**EPC STORMWATER REVIEW COMMENTS  
IN ORANGE BOXES WITH BLACK TEXT**

**SMALL SUBDIVISION FINAL DRAINAGE REPORT  
FOR  
CLOVERLEAF FILING NO. 1**

**December 1, 2020**

**Add text:  
PCD Filing No.: SF-21-014**

LOT 142
0.51 AC

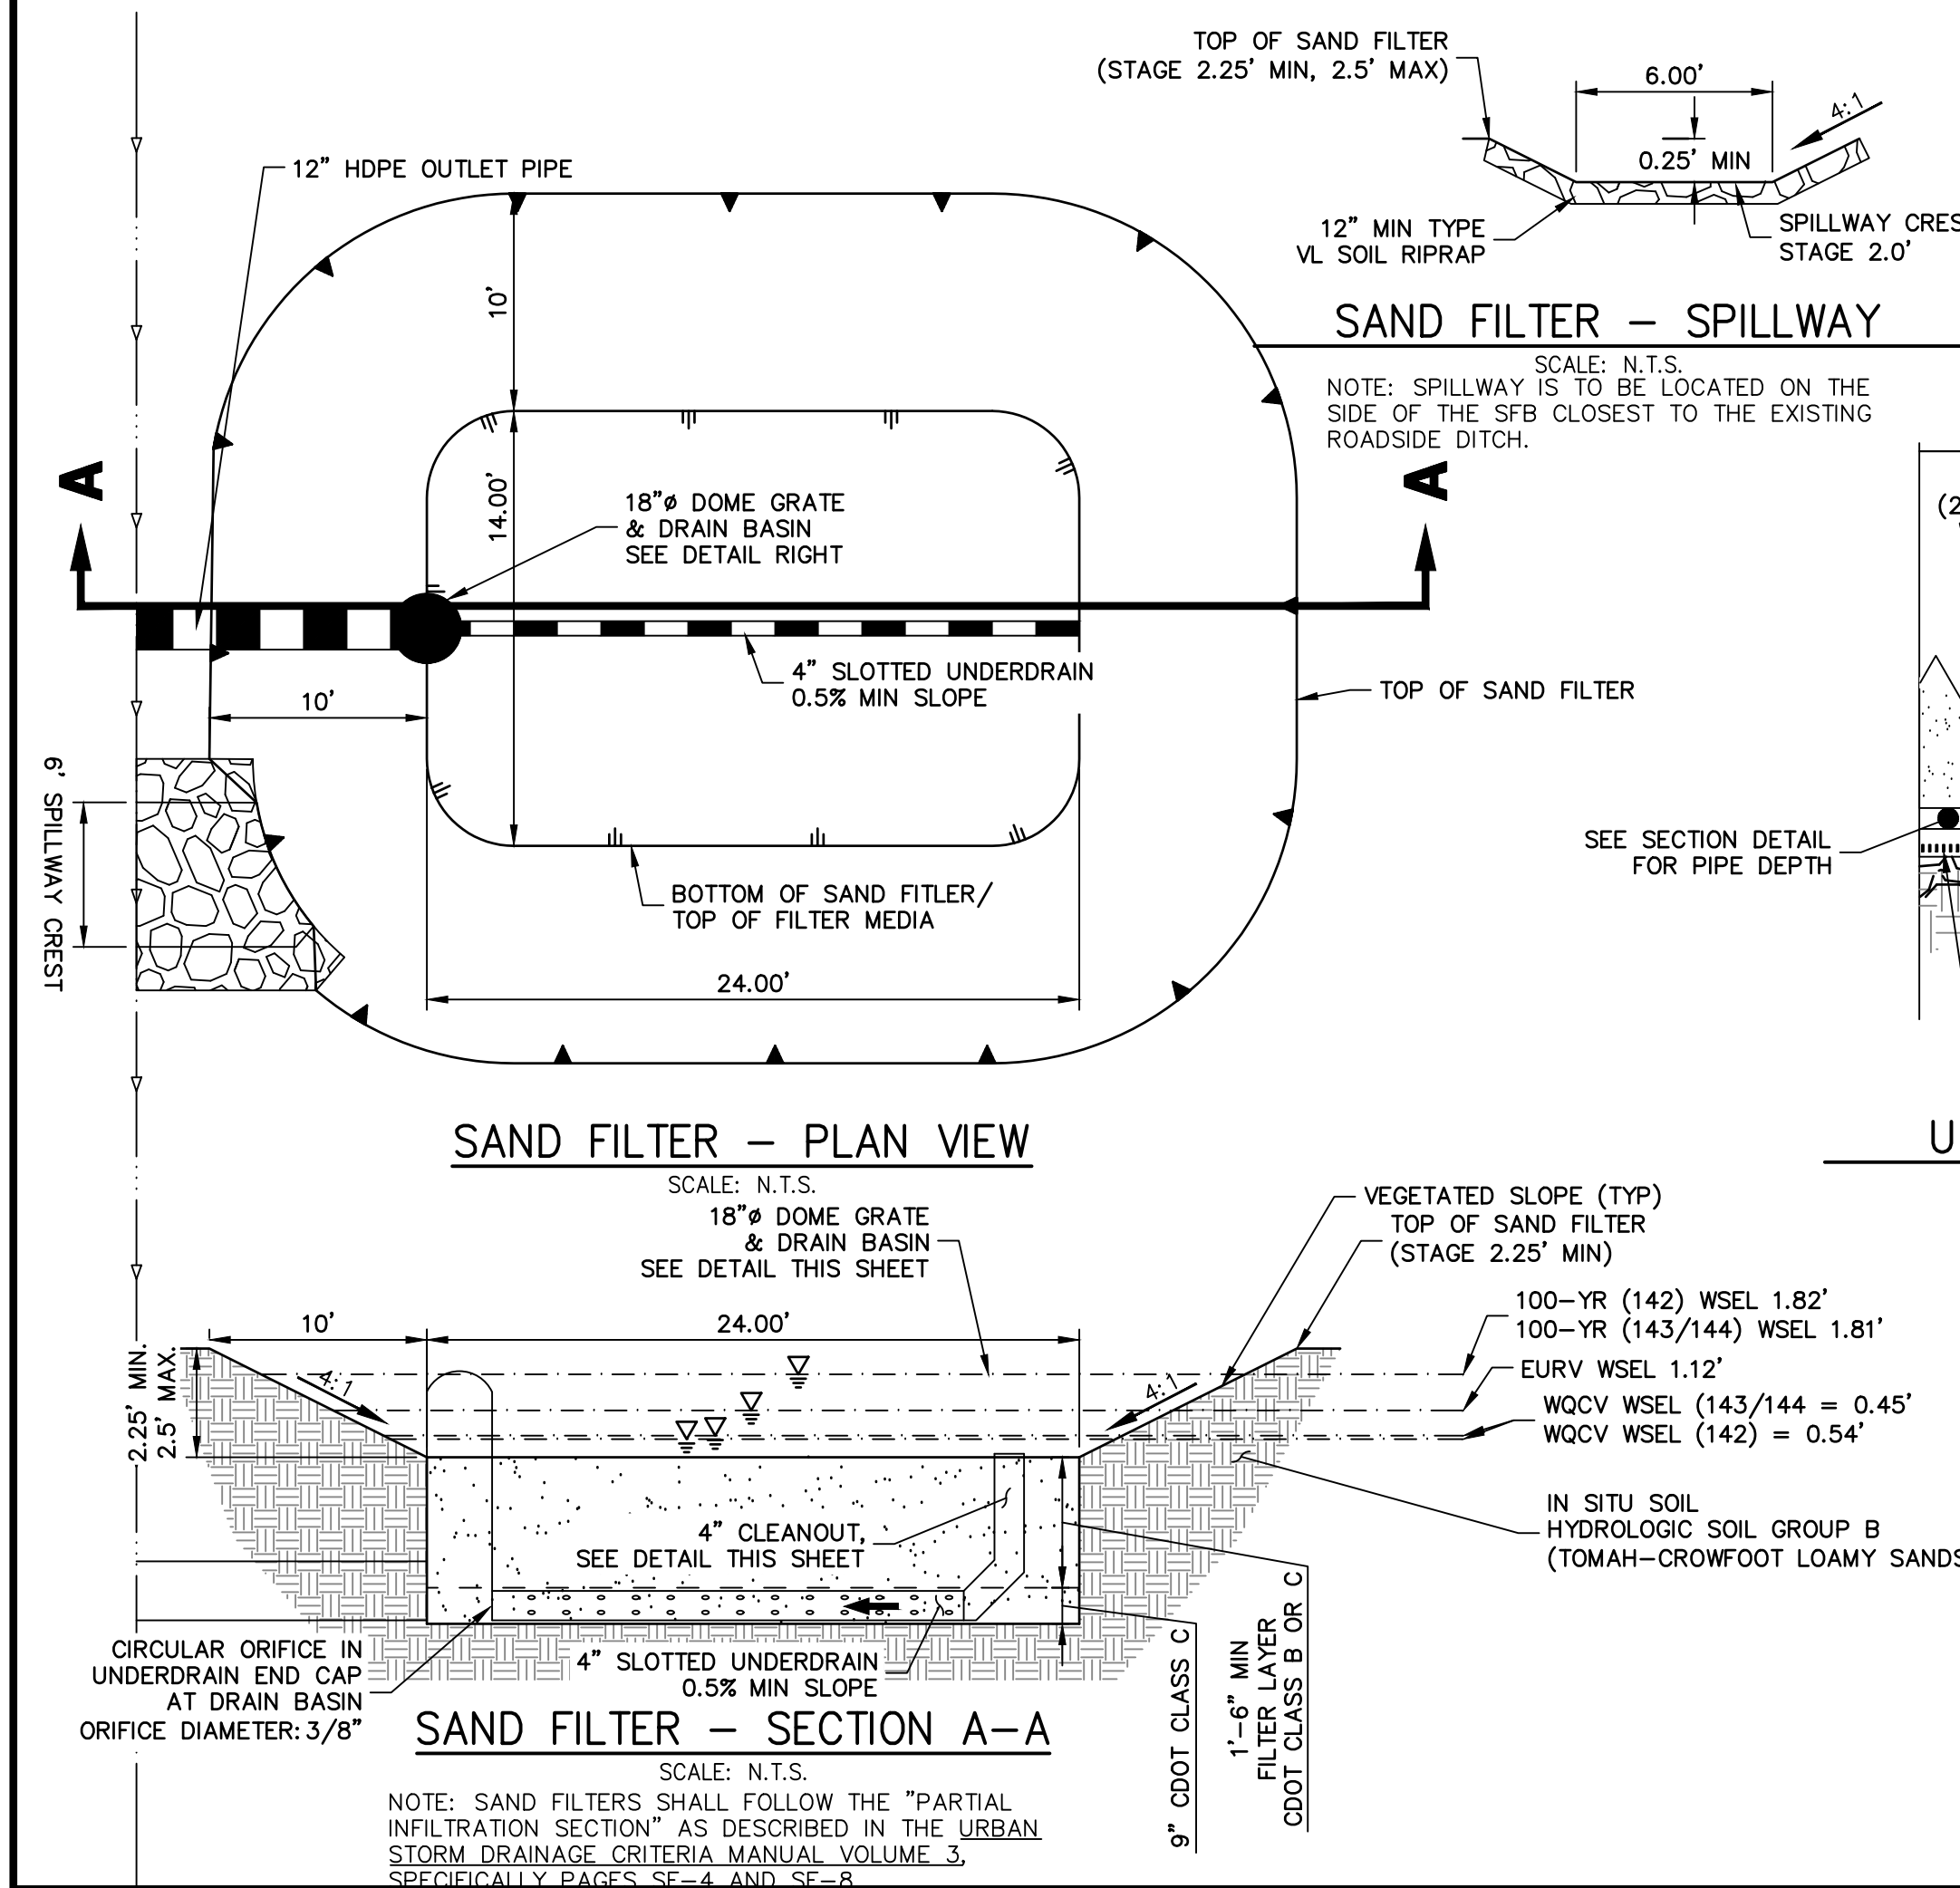
Please explain how. Is there a berm around the property to prevent offsite flow from entering the site? It looks like the land to the east of lots 143 and 144 flows onto these lots.  
If needed, include tributary basins into the rational method calcs in Appendix B

Addressed: Section details consisting of berms and swales were added to the proposed drainage map to demonstrate the anticipated lot grading. In general, berms will be installed on the uphill sides of lots where offsite flows currently enter the lots. The berms will route the offsite runoff around the lots and back to their existing drainage paths on the downstream side. Swales will intercept on-site generated runoff and transport it to the proposed Full-Spectrum SF's.
